Development Control
Ribble Valley Borough Council

App no: 23.0216

Address: Kitchens Cross Lane Bashall Eaves BB7 3NA

Proposal: Erection of new stable block and change of use of land for all-weather manege for private use. Previously dismissed at appeal APP/T2350/W/21/3281836

drawing number BE-25-10-22-C

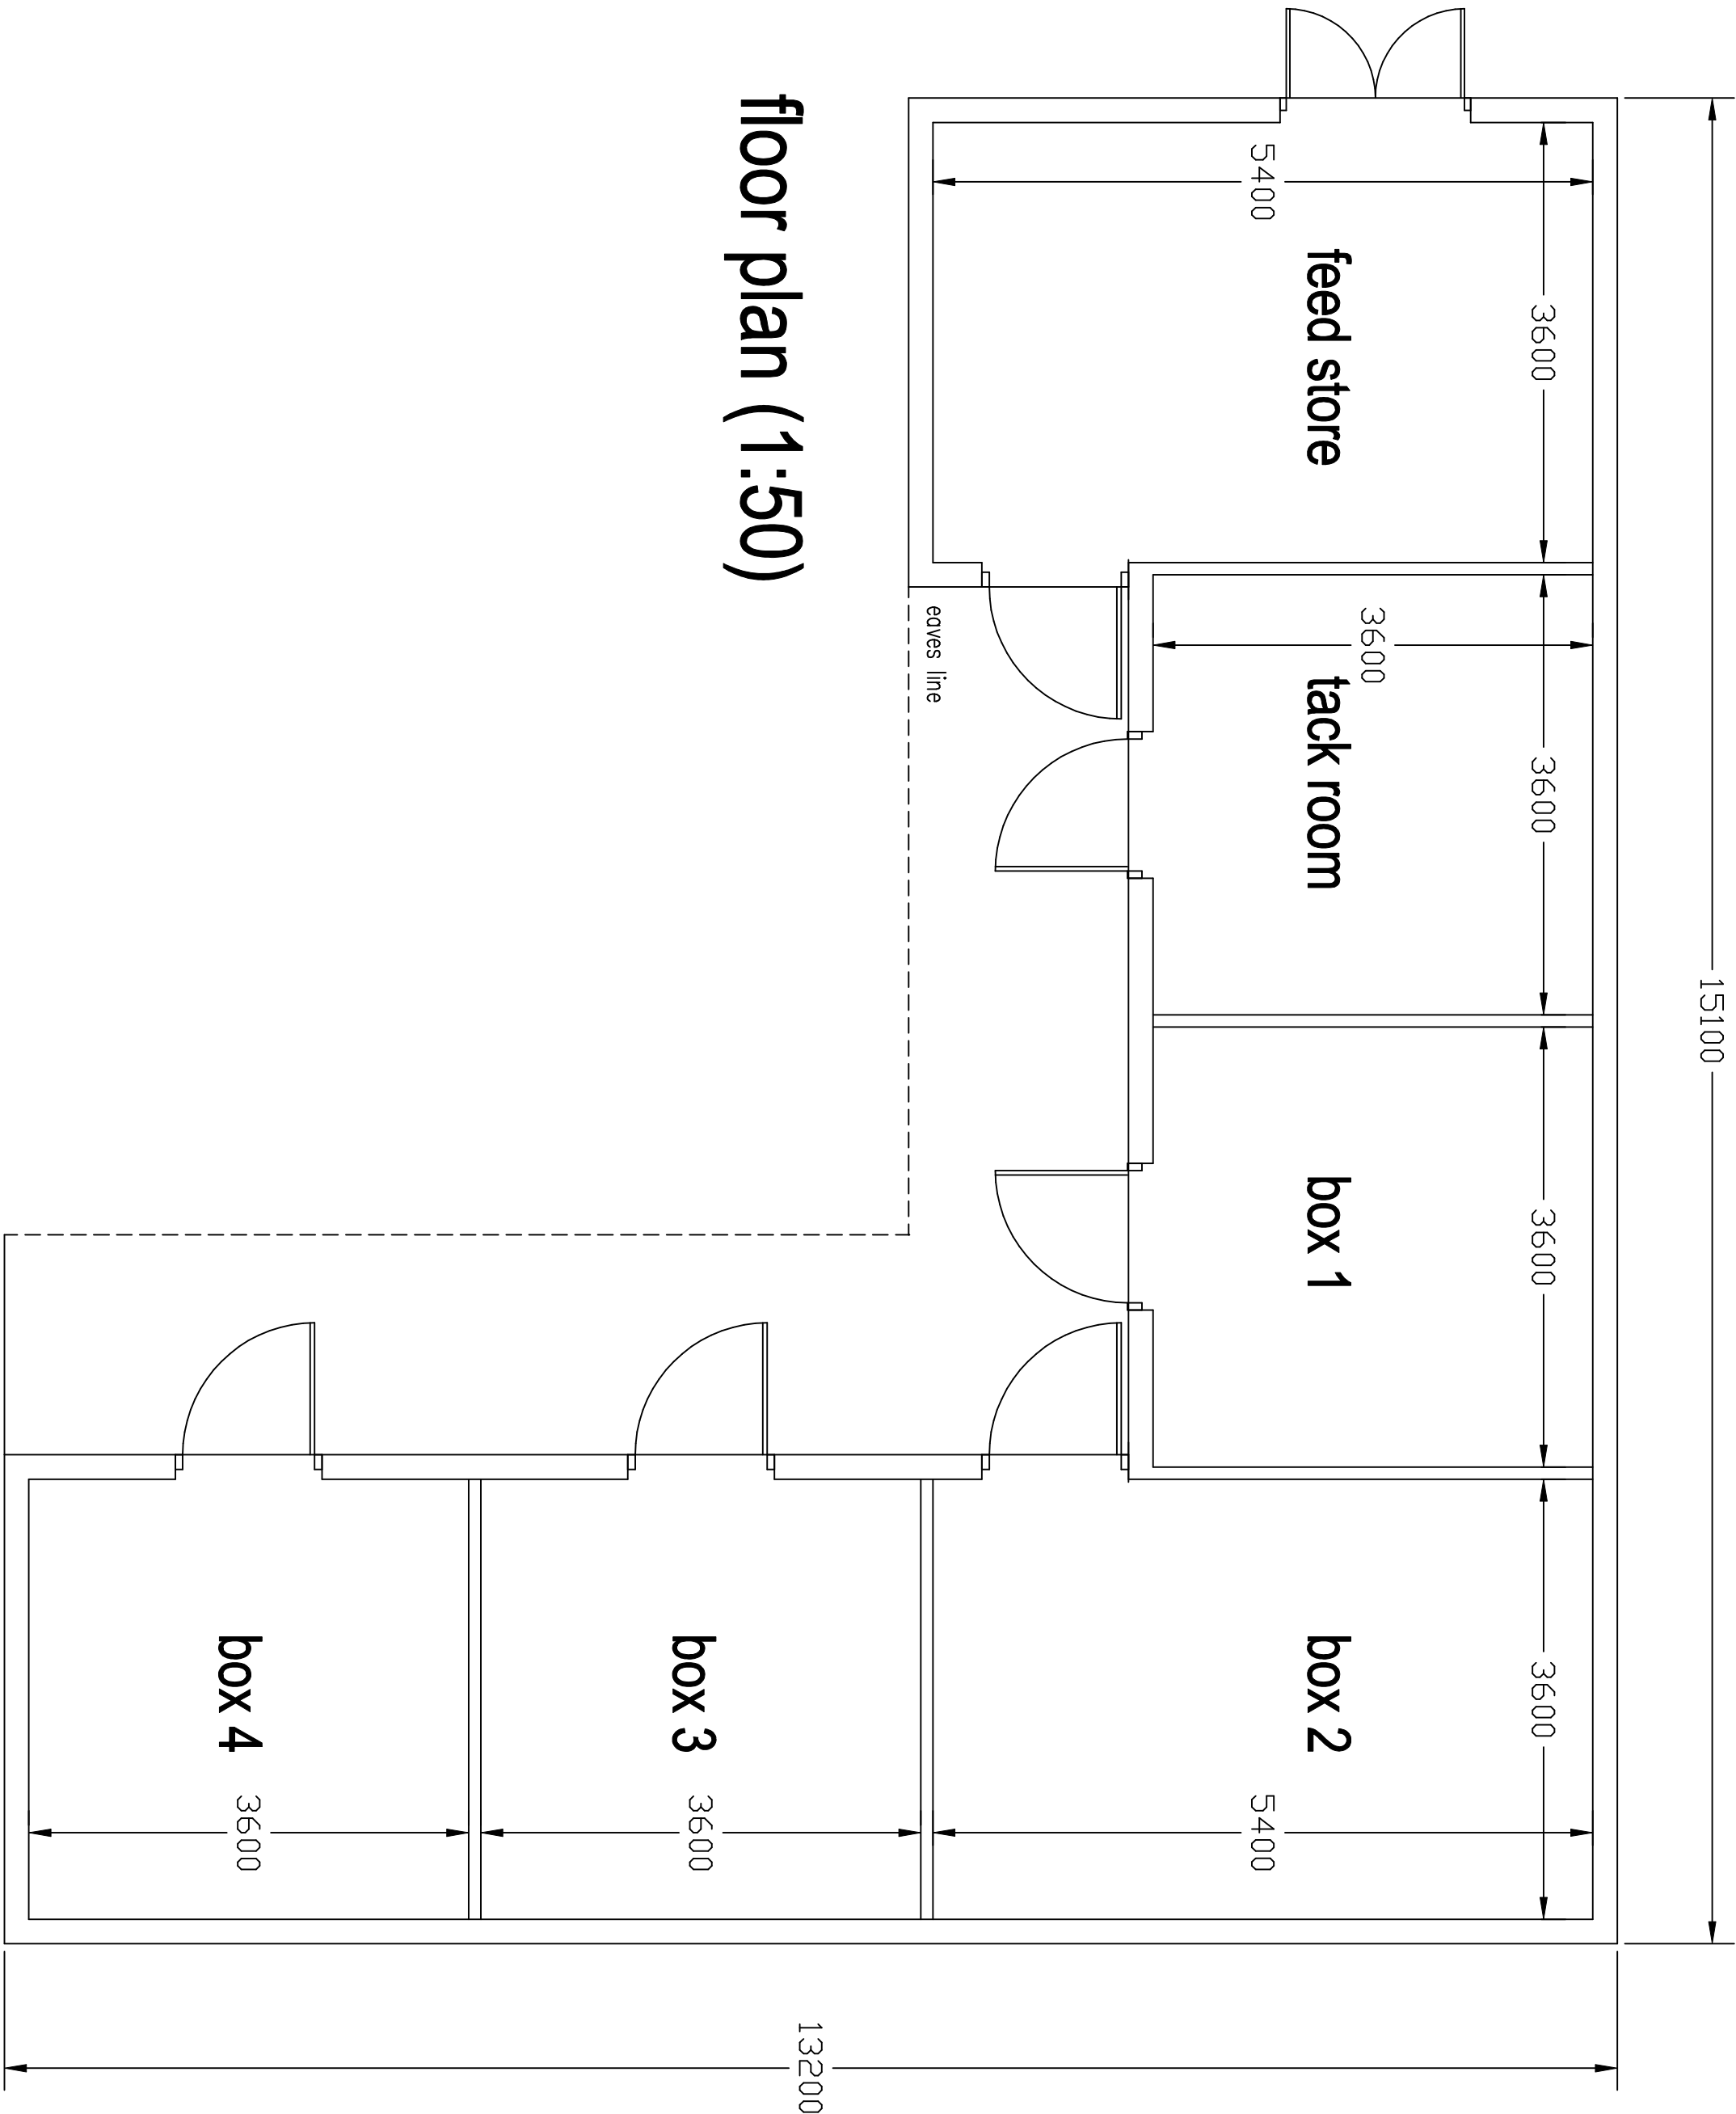
The applicant proposes to widen the site access to 9m and this is supported by the Highway Authority. The gates are set back 10m from the edge of the highway as

previously requested. There is sufficient hardstanding internally to allow vehicles to turn and leave in forward gear onto Cross Lane.

1. The proposed access from the site to Kitchens Cross Lane shall be constructed to a width of 9 metres and this width shall be maintained for a minimum distance of 10 metres measured back from the nearside edge of the carriageway. Reason: To enable towed vehicles to enter and leave the premises in a safe manner without causing a hazard to other road users'. Reason: In the interest of highway safety
2. The development hereby permitted shall be used for, or ancillary to, the stabling of horses owned by or leased by the occupier of Kitchens only, and shall not be used for livery, equestrian events or any commercial purpose whatsoever at any time. Reason: In the interest of highway safety
